Application No: LU/312/20/HH
Site Address: 18A River Road Littlehampton BN17 5BN
Description of works: Part conversion of garage to create an self contained annex

Thank you for your internet representation made on 9th January 2021 which has been recorded as an objection with the comments as follows:

proposed ground floor plan:
No change to elevations:

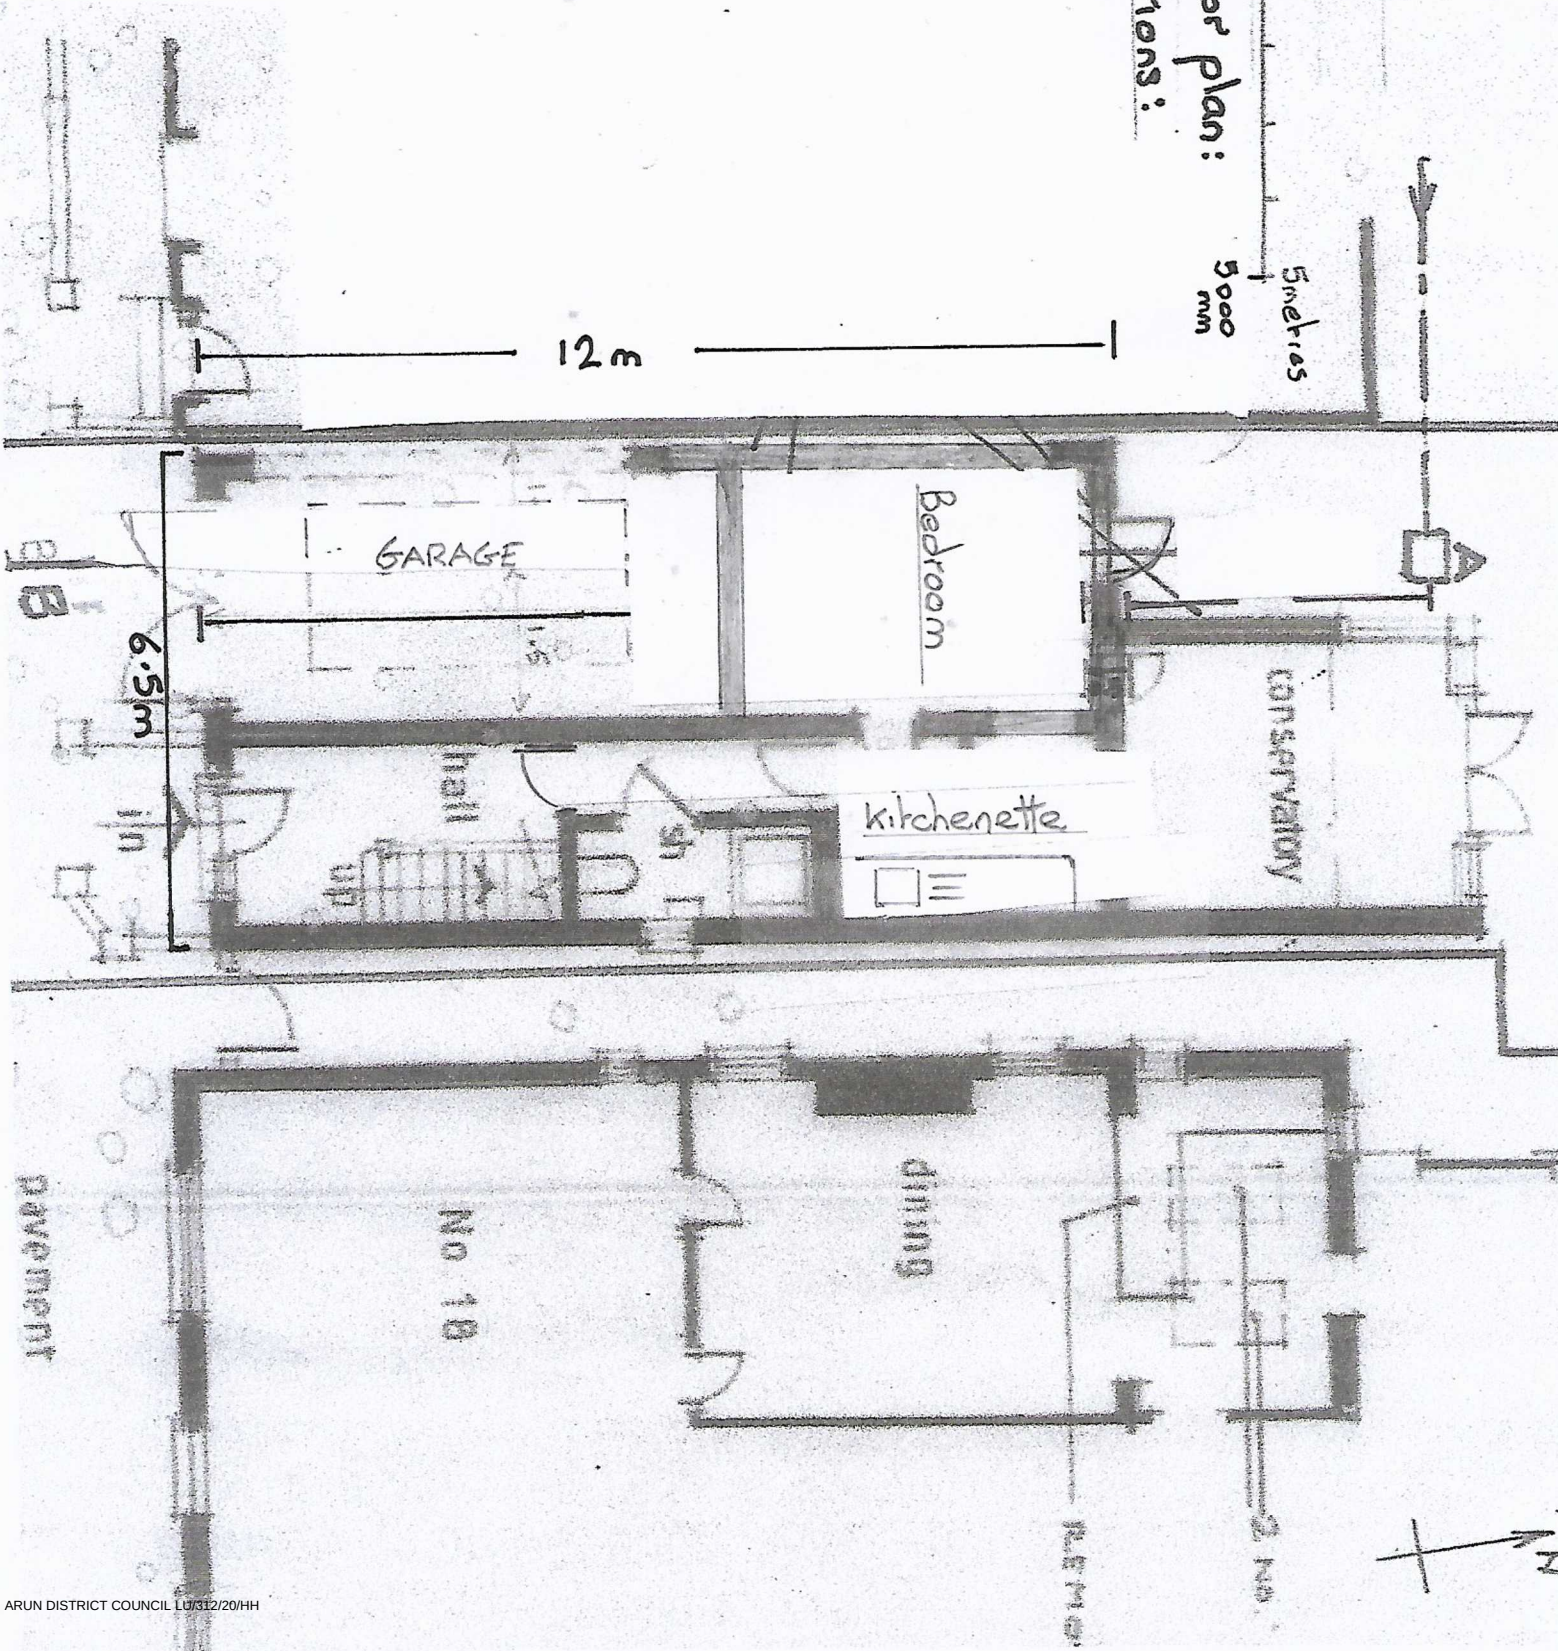
- 1/ access to the property for wheelchair
- 2/ Access within the property for wheelchair
- 3/ access to proposed kitchenette
- 4/ access to bathroom and toilet facility non on ground level

- 10/ the space allocated to cars - not able to park a car within due to adaptation.
- 11/ This is being run as an Air BnB property
with one flat being used possibly by owner/occupier, with cars coming and going
the owner occupier has two cars between them - neither go inside
